THE TRAILS AT ASPEN RIDGE FILING NO.2

A SUBDIVISION OF A PORTION TRACT Q AND TRACT R OF THE TRAILS AT ASPEN RIDGE FILING NO.1 LOCATED IN THE WEST 1/2 OF SECTION 9, TOWNSHIP 15 SOUTH, RANGE 65 WEST OF THE 6TH P.M. EL PASO COUNTY, COLORADO

SHEET 1 OF 4

**THE TRAILS AT ASPEN RIDGE FILING NO.2**  
 A SUBDIVISION OF A PORTION TRACT Q AND TRACT R OF THE TRAILS AT ASPEN RIDGE FILING NO.1  
 LOCATED IN THE WEST 1/2 OF SECTION 9,  
 TOWNSHIP 15 SOUTH, RANGE 65 WEST OF THE 6TH P.M.  
 EL PASO COUNTY, COLORADO  
 SHEET 2 OF 4

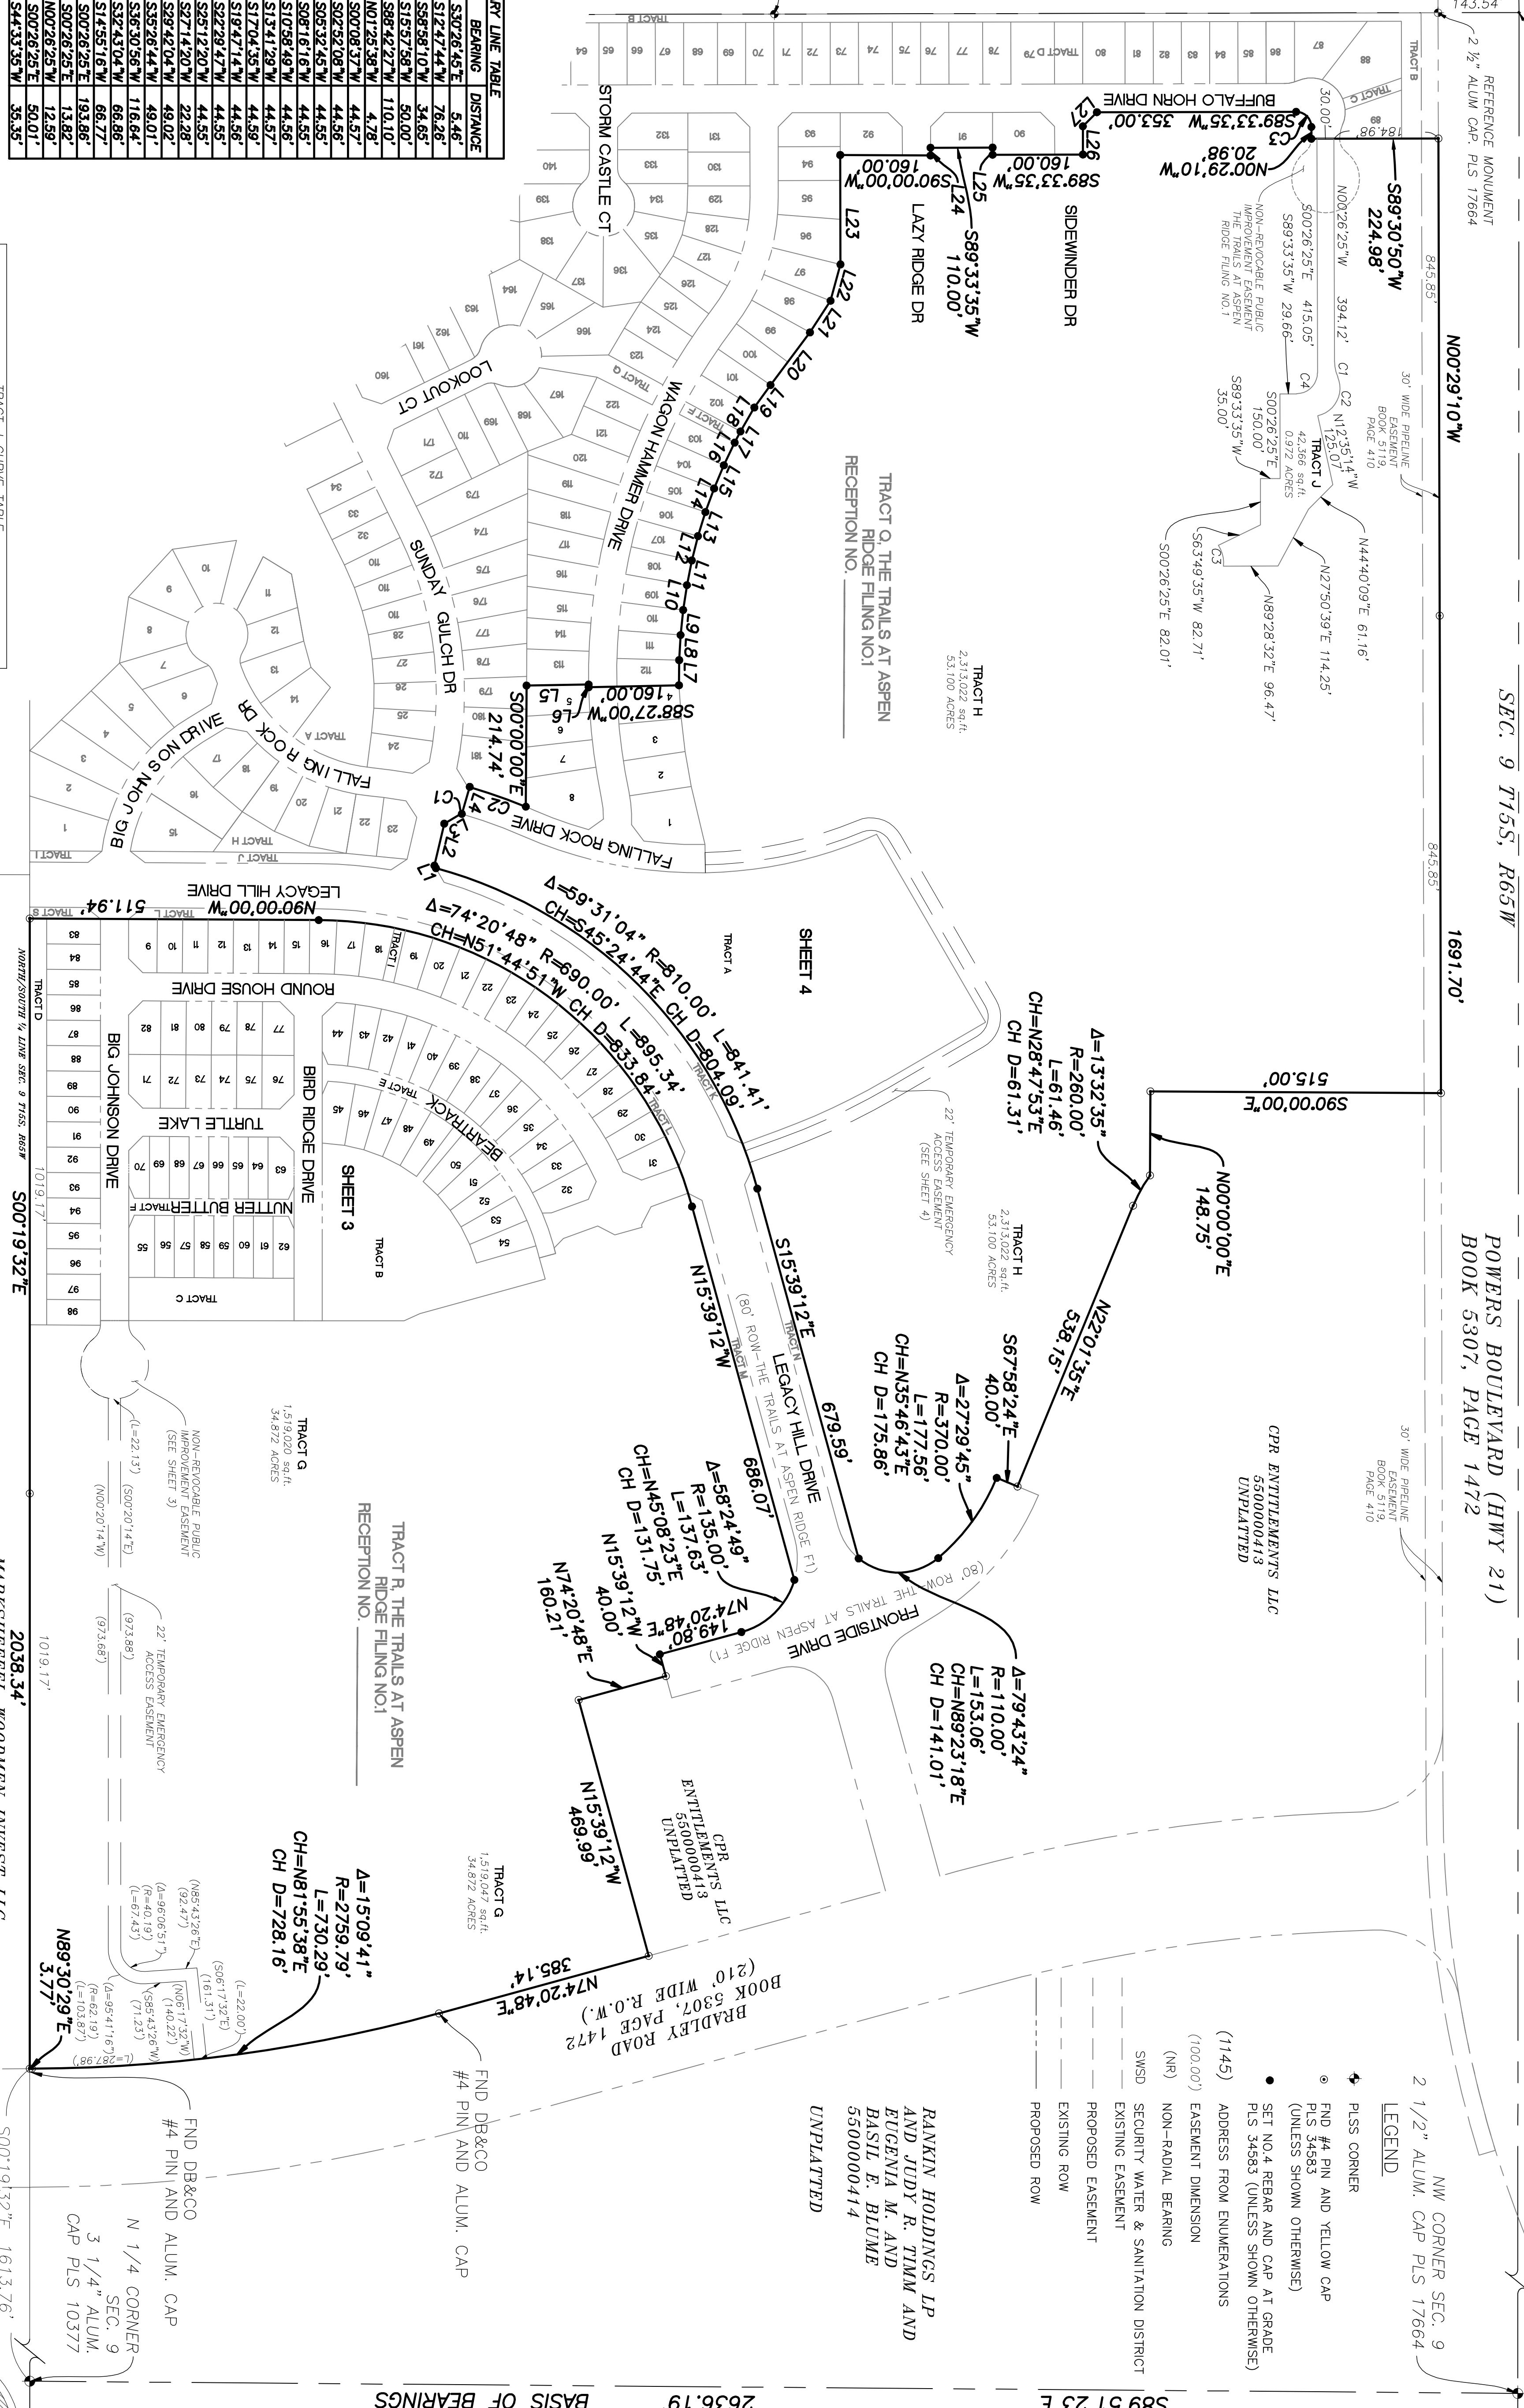
I do not think this is the correct reception no or reso number. Please work with Lori Segg to enter into a PID
